KIRKLEES METROPOLITAN COUNCIL INVESTMENT & REGENERATION SERVICE

DELEGATED DECISION TO DETERMINE APPLICATIONS FOR CONSENT, AGREEMENT OR APPROVAL REQUIRED BY CONDITION

Reference No:	2026/44/90948/W
Site Address:	The Hayloft, Highfield Gate Farm, Highfield Road, Slaithwaite, Huddersfield, HD7 5UT
Description:	Discharge of details reserved by conditions 4 (materials), 5 (windows and doors), 6 (boundary treatments) and 7 (landscaping) on previous permission 2024/90134 for demolition of existing dwelling and erection of one dwelling with associated parking and landscaping
Recommending Officer:	John Holmes

DECISION – Discharge of Conditions - Approved

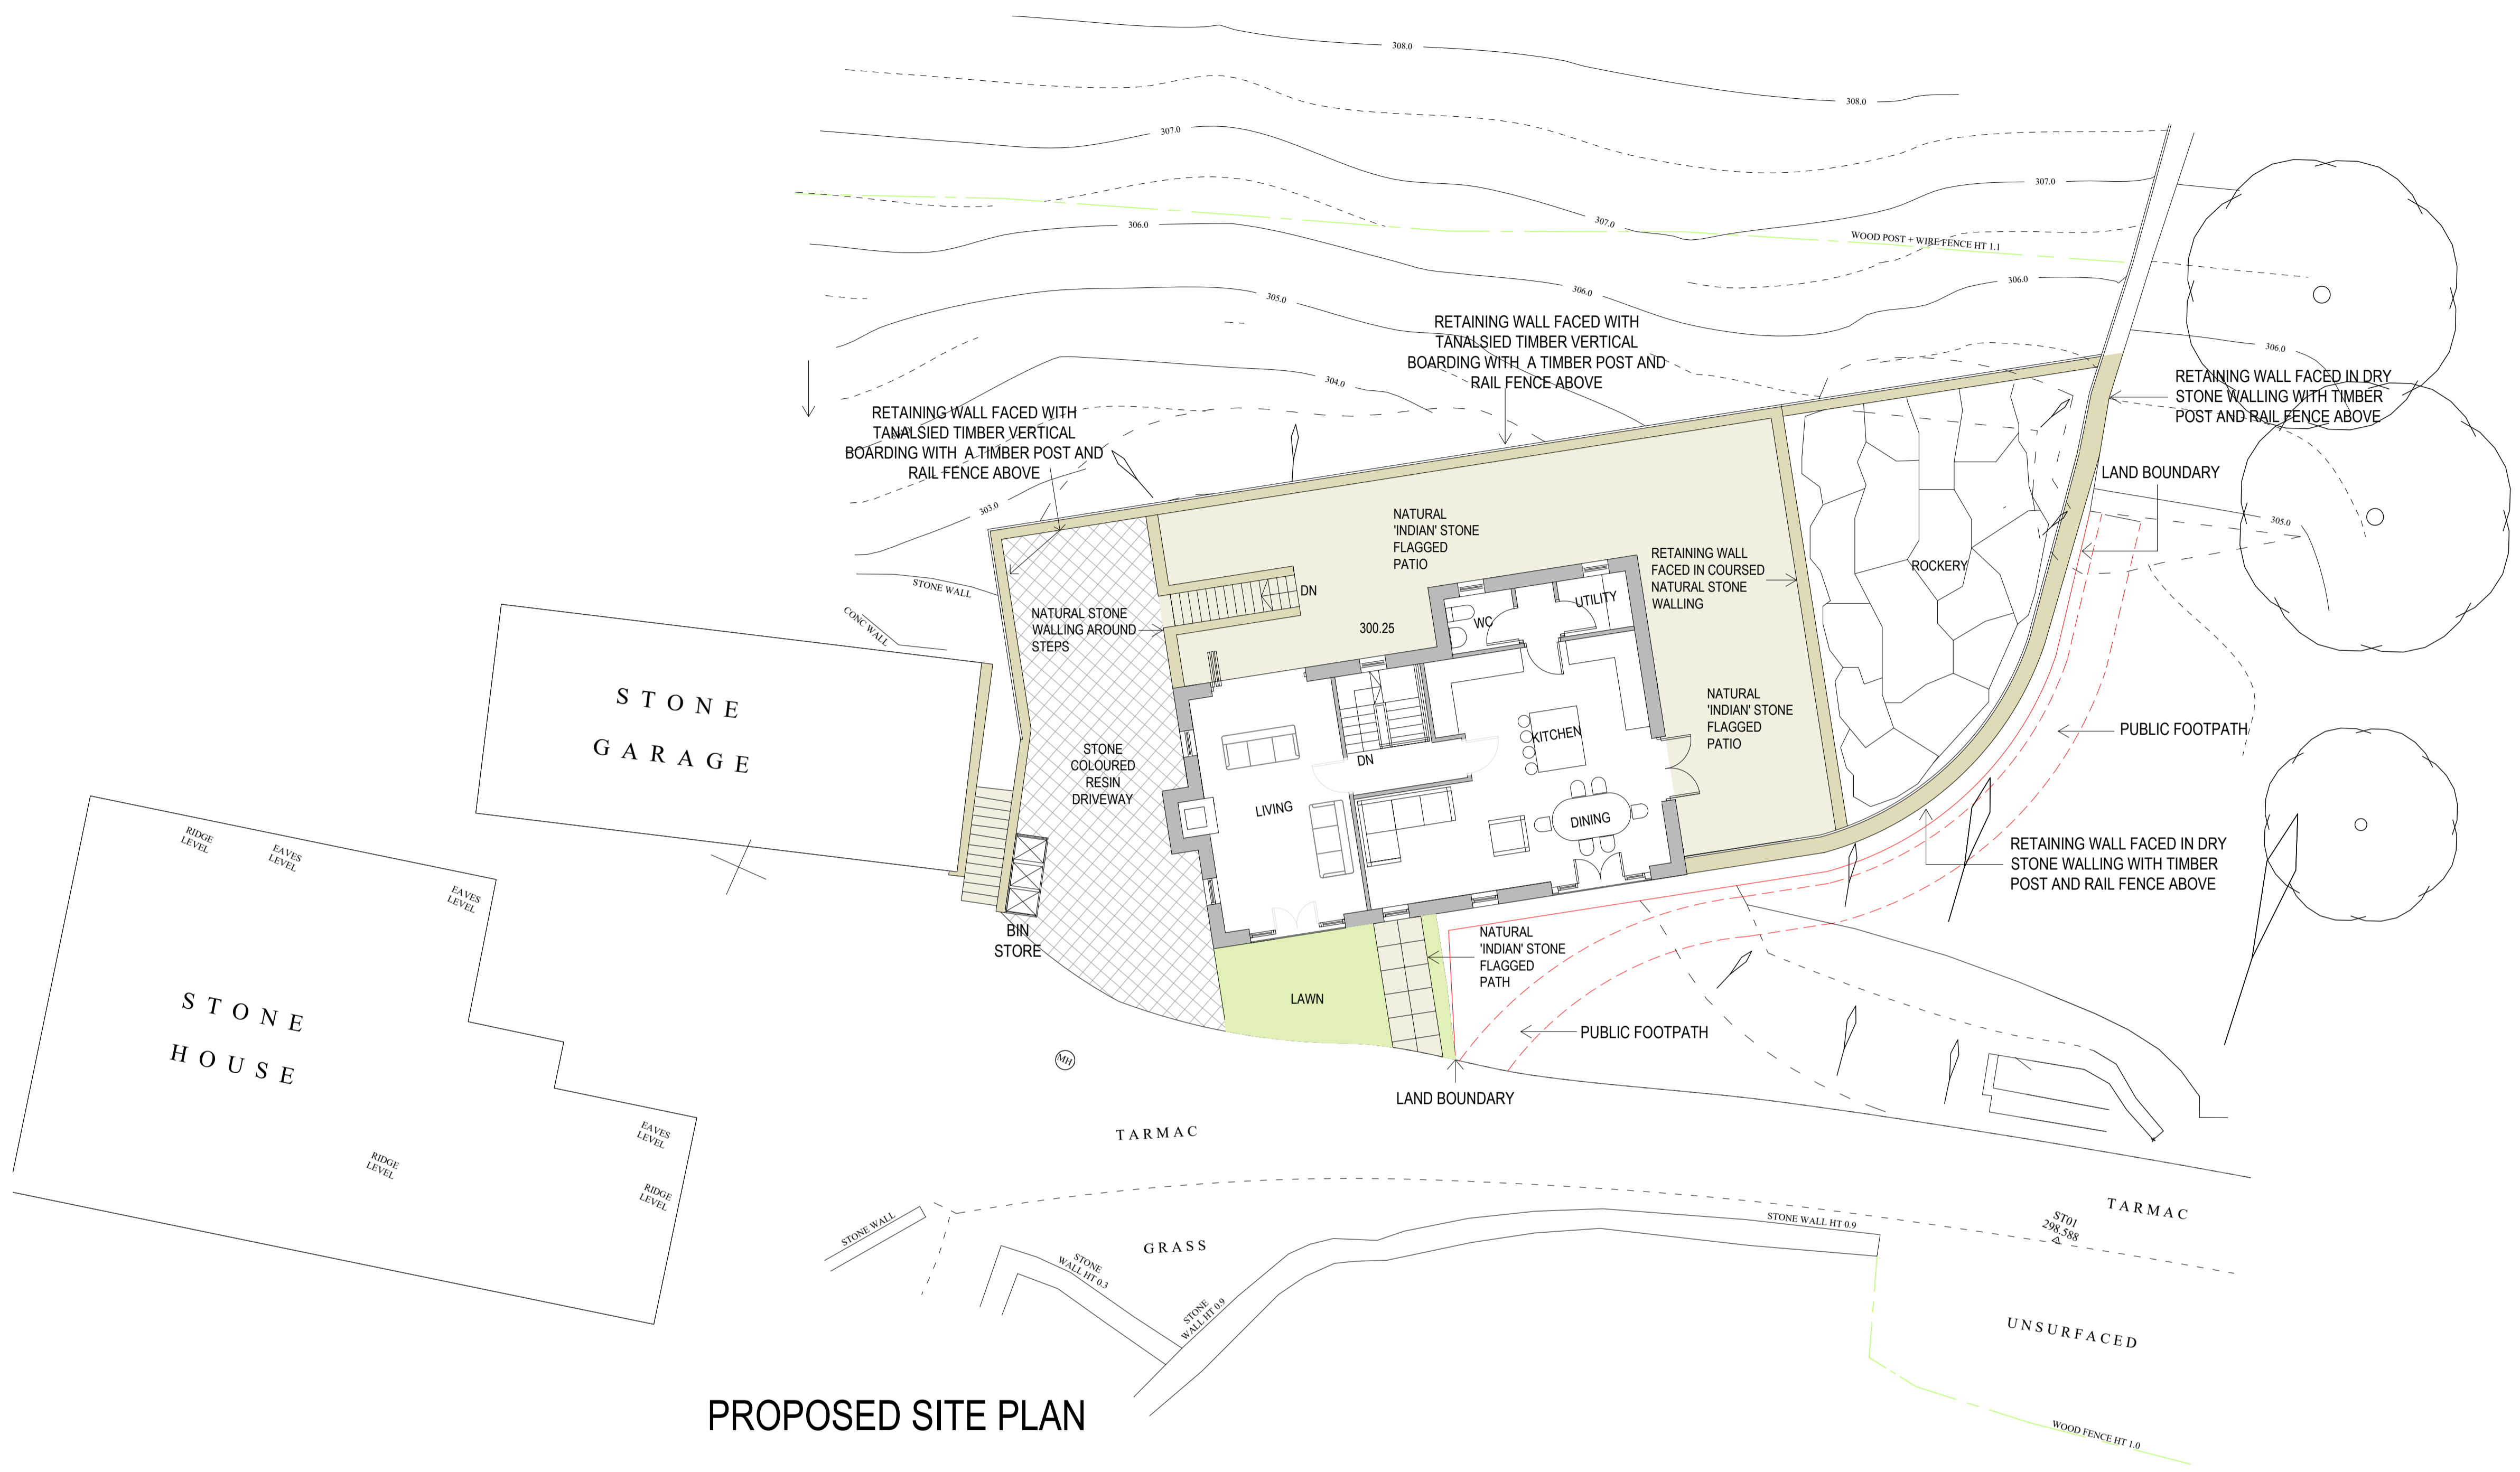
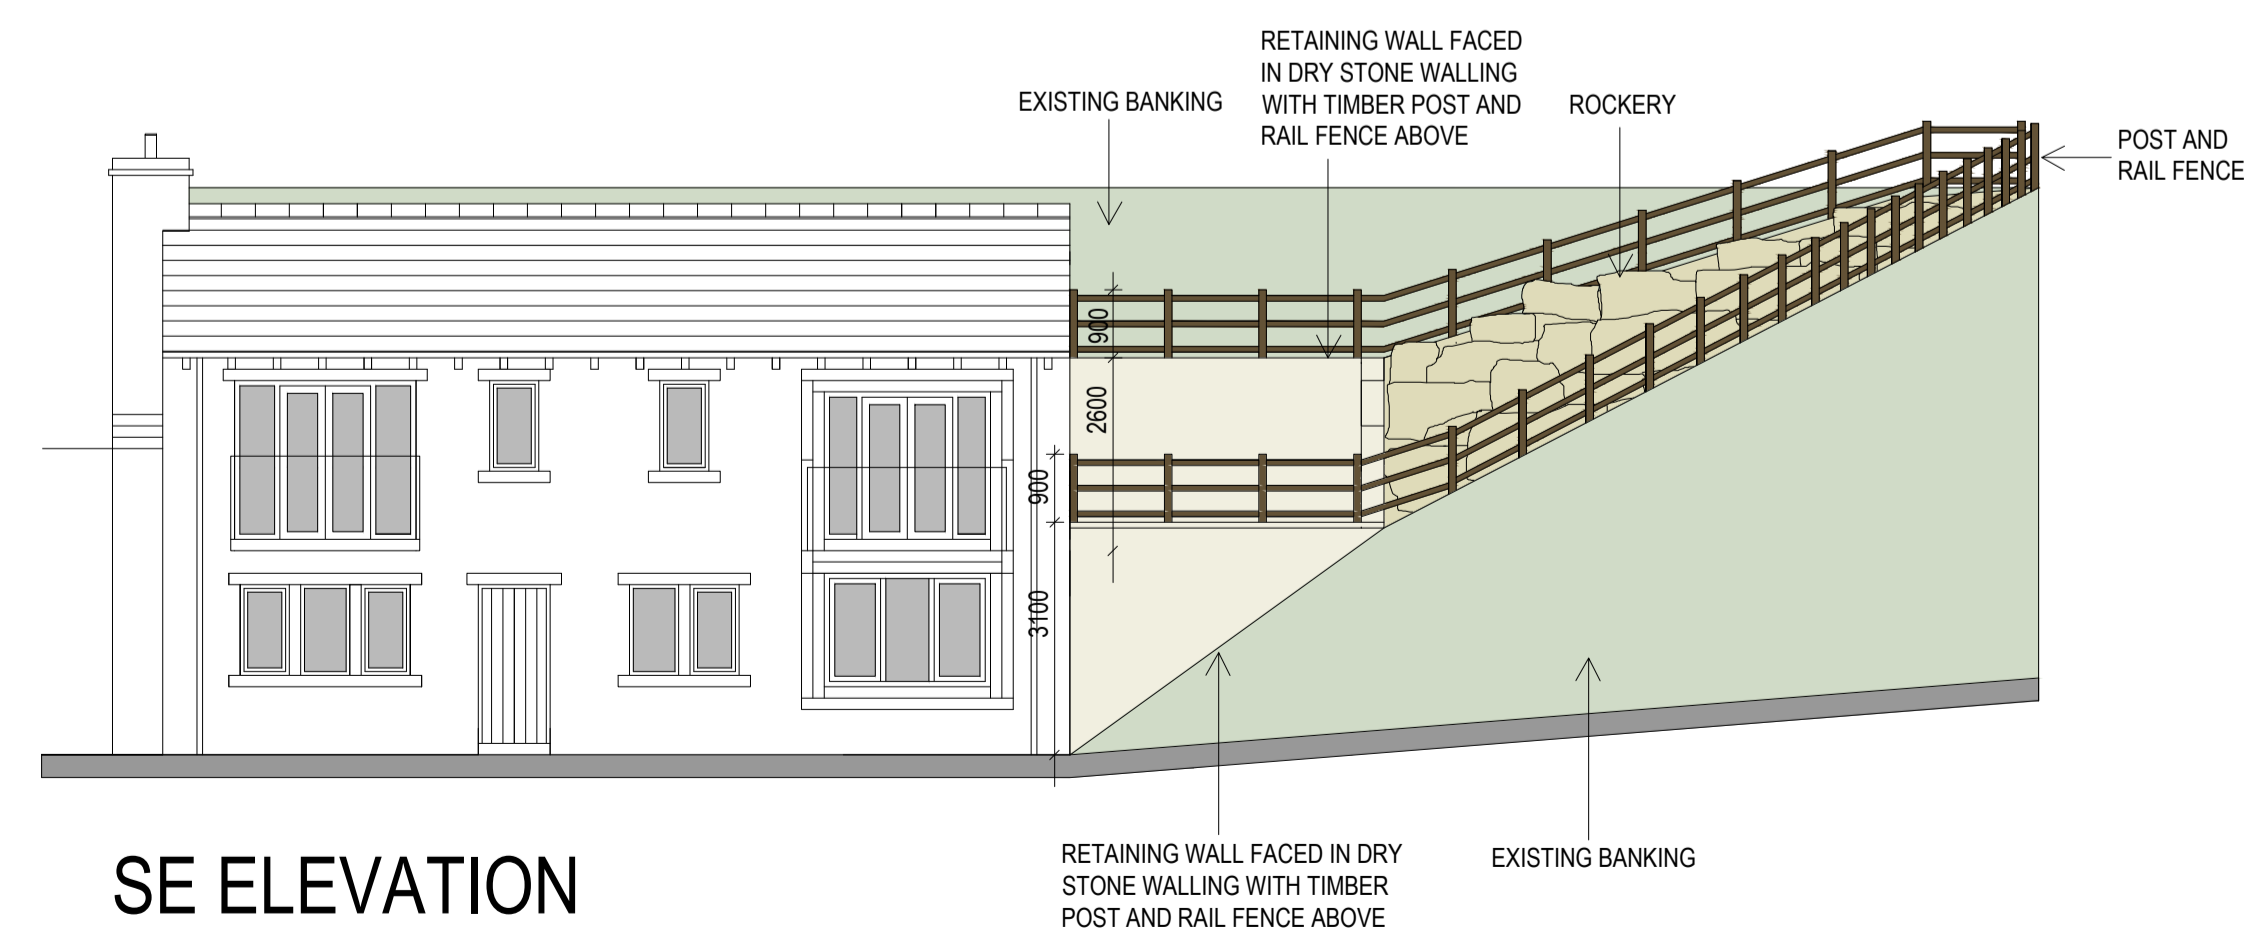
The submitted scheme details the boundary of the site would consist of post and rail fencing which would be above a retaining wall that is to be faced in a dry stone wall materials. Drawing 03revE does make reference to use of timber vertical boarding for parts of the retaining wall which are to the rear of the dwelling. It is considered that the use of stone / timber for the facing material of retaining structures would suitably integrate into the landscape in

this case, having regard to the existing topography and development undertaken at the site already. The design of the post and rail fence is demonstrated in the submitted scheme which shows it would be a low level and open boundary treatment which follows the extent of the approved curtilage of the site.

Section 5 of the submitted document sets out that the landscaping ethos is dictated due to the limited curtilage and topography. The identified approach to the landscaping is intended to be predominantly hard. The dwelling will be surrounded by a stone flagged patio, with the steep eastern slope being landscaped with large tiered boulders to form a rockery. There is an area to the front for a small lawn.

Whilst the phasing of the scheme is not set out in the submitted detail, on the basis it is provided within the 1st planting season following the development being brought into use it is considered the proposed landscaping sets out a suitable approach which will suitably integrate within the landscape. The

topography is such that it would be difficult for a lawned area to be provided, and the extent of curtilage is such that hard standing patio areas would not dominate the character of the building / locality given this is relatively limited. The use of hardstanding patio also ensures a usable amenity space.

It is therefore concluded that the submitted scheme is acceptable and that condition no.6 be discharged on this basis.

It is therefore concluded that on the basis of the stipulation the scheme is implemented within the aforementioned timeframe, the proposal would have an acceptable impact in terms of proposed landscaping. The condition is therefore recommended to be discharged.
